To: All Staff
From: Environmental Health
Date: 6/18/2026
Subject: SP-26-00004 Moulton

MOULTON SHORT PLAT
PART OF SECTION 1, T. 18 N., R. 17 E., W.M.
KITITAS COUNTY, WASHINGTON

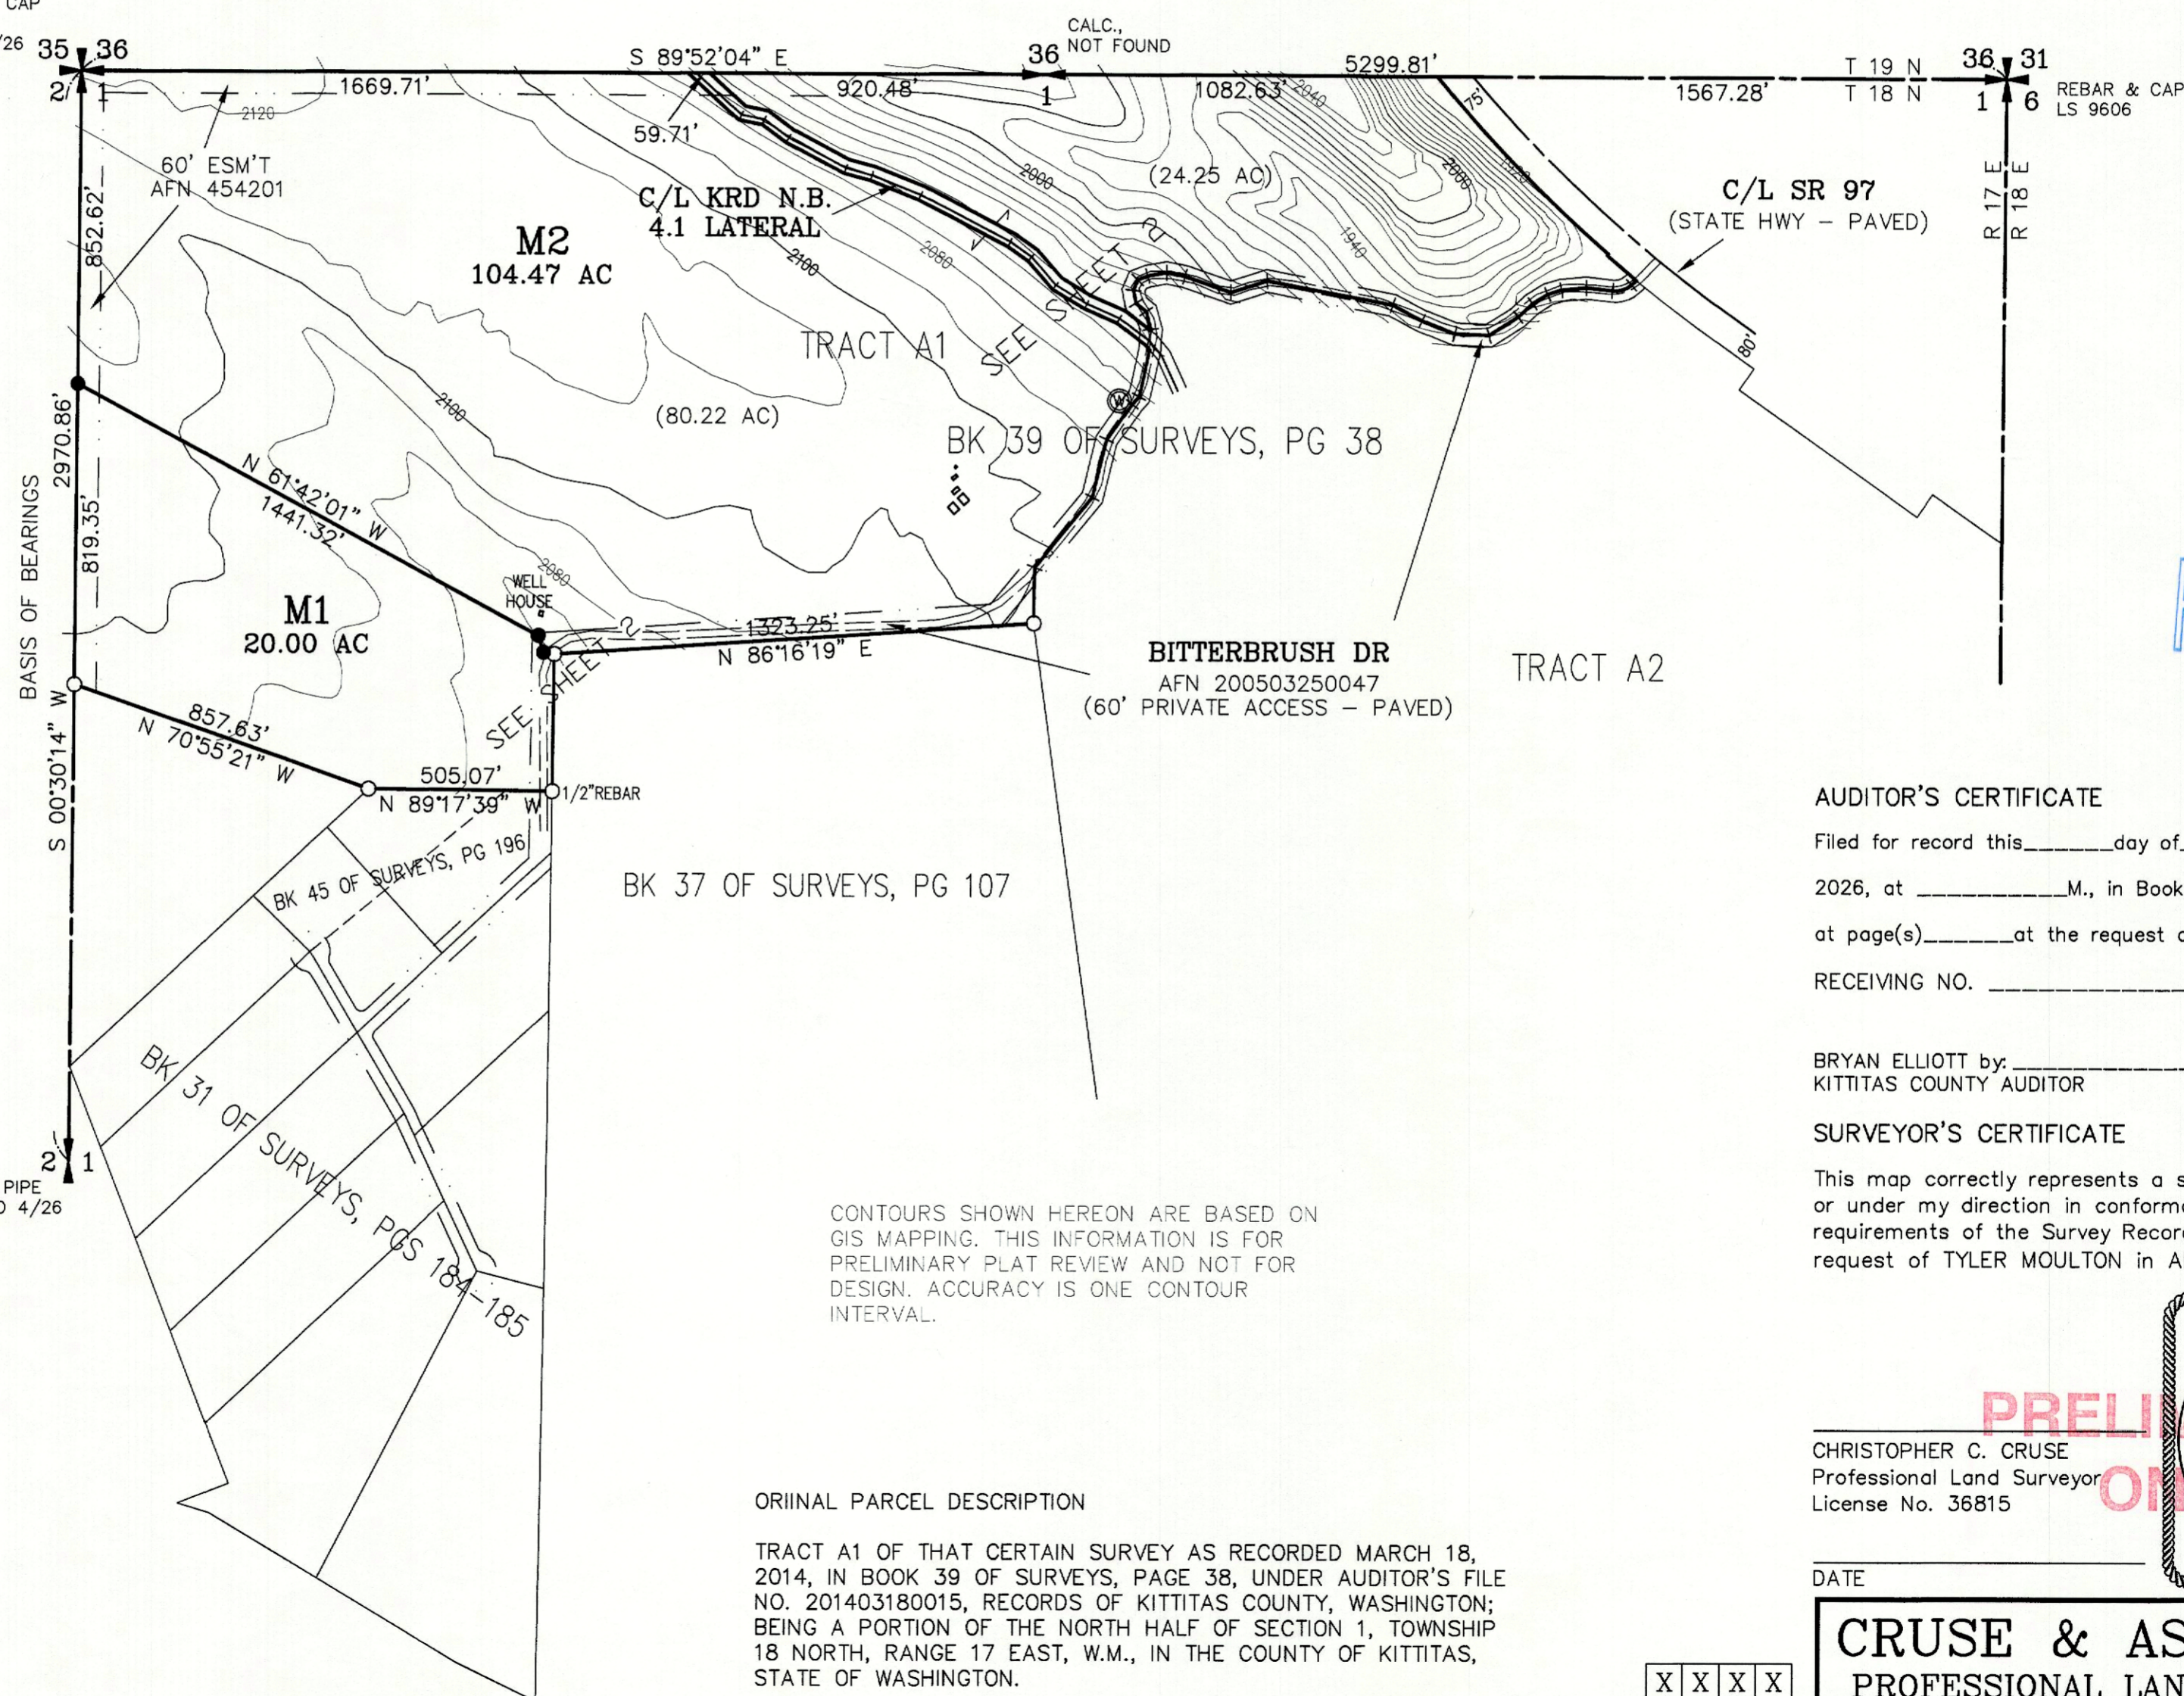
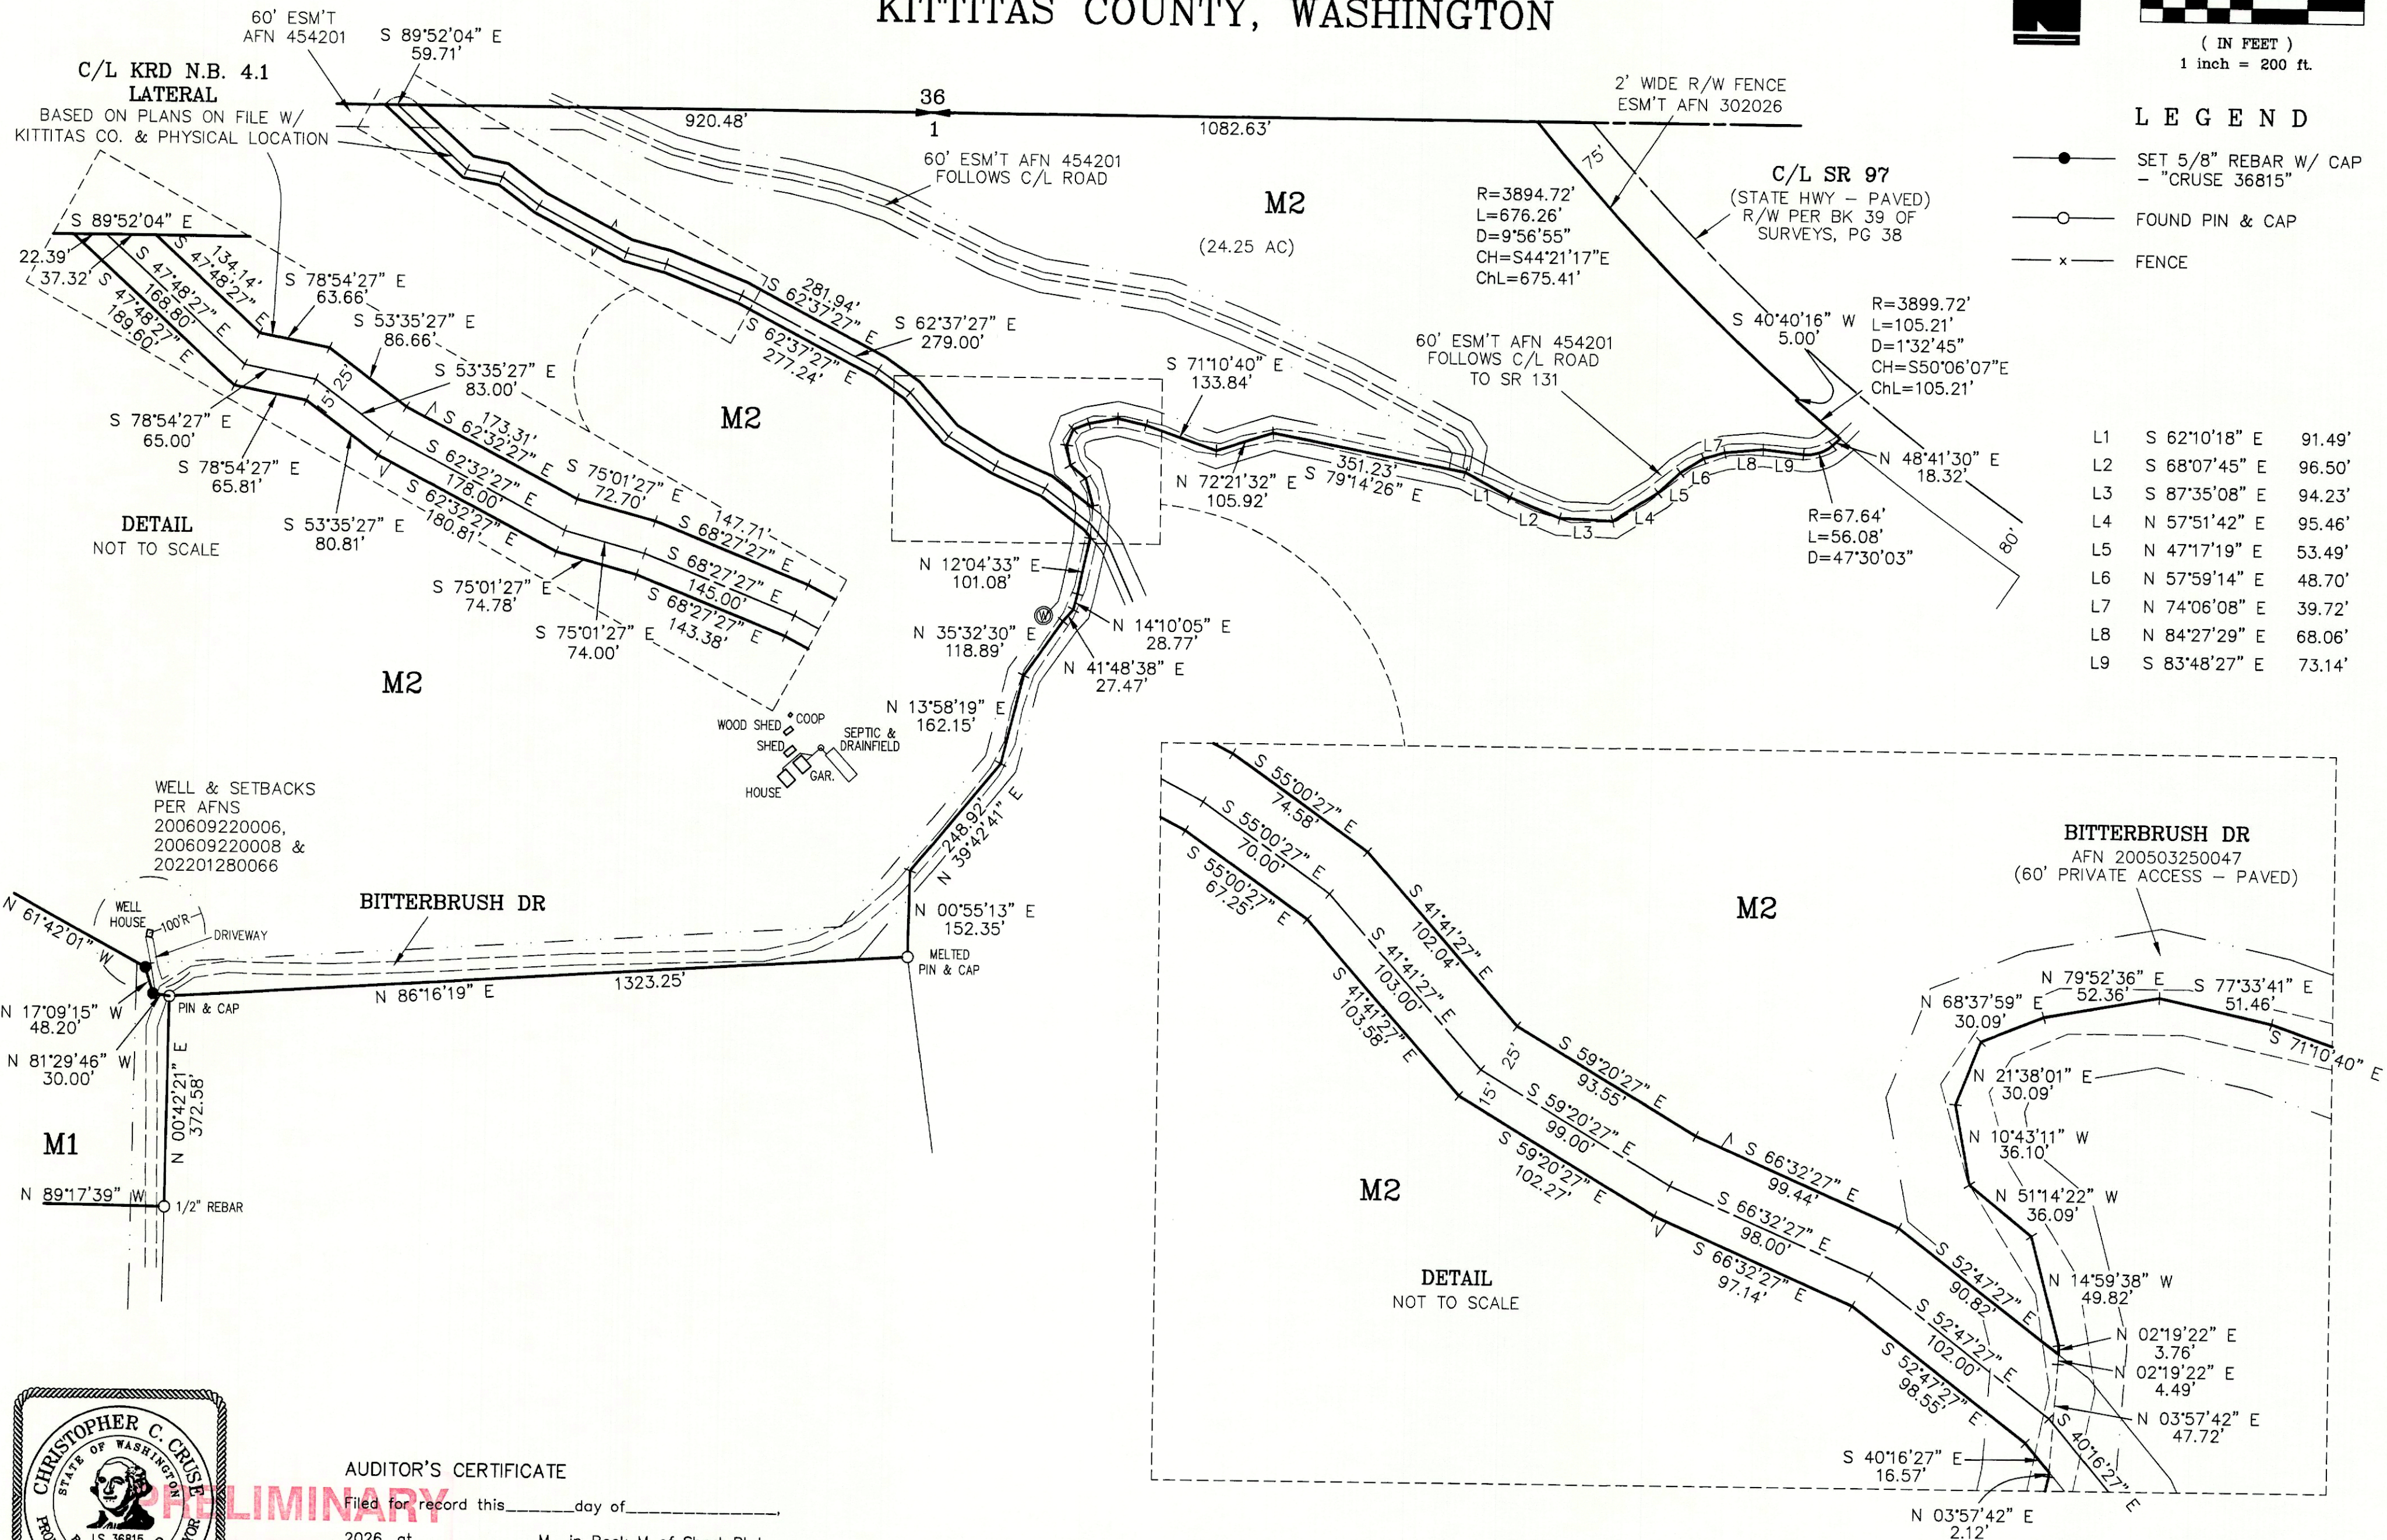
Wastewater	• Prior to preliminary plat approval, the applicant shall perform soil logs in accordance with KCC 13.08.040 to demonstrate that the proposed lots can support conforming on-site sewage systems and required reserve areas. The evaluation shall include a minimum of two soil test pits per lot within the primary and reserve drainfield areas, and the test pit locations shall be shown on the plat map and flagged in the field for inspection.
